Application for Planning Permission for Works or Extension to a Dwelling

Development: Erection of single storey front extension and timber shed in front garden.
Location: 58 Outerwyke Road Felpham PO22 8NF

BLOCK PLAN 1:500

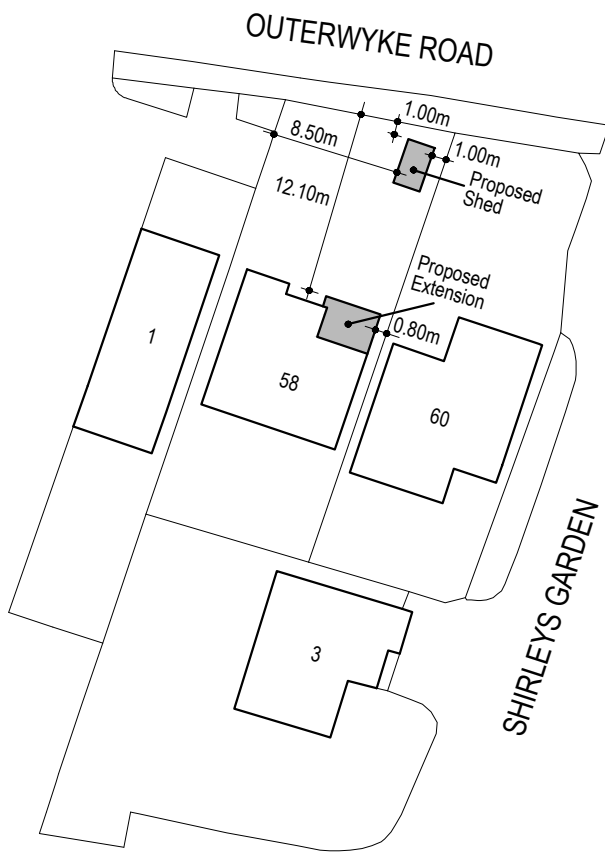
Block Plan

You are required to have dimensions from the proposed extension(s) to all site boundaries. The other side dimension from the proposed timber shed is missing. Please amend.
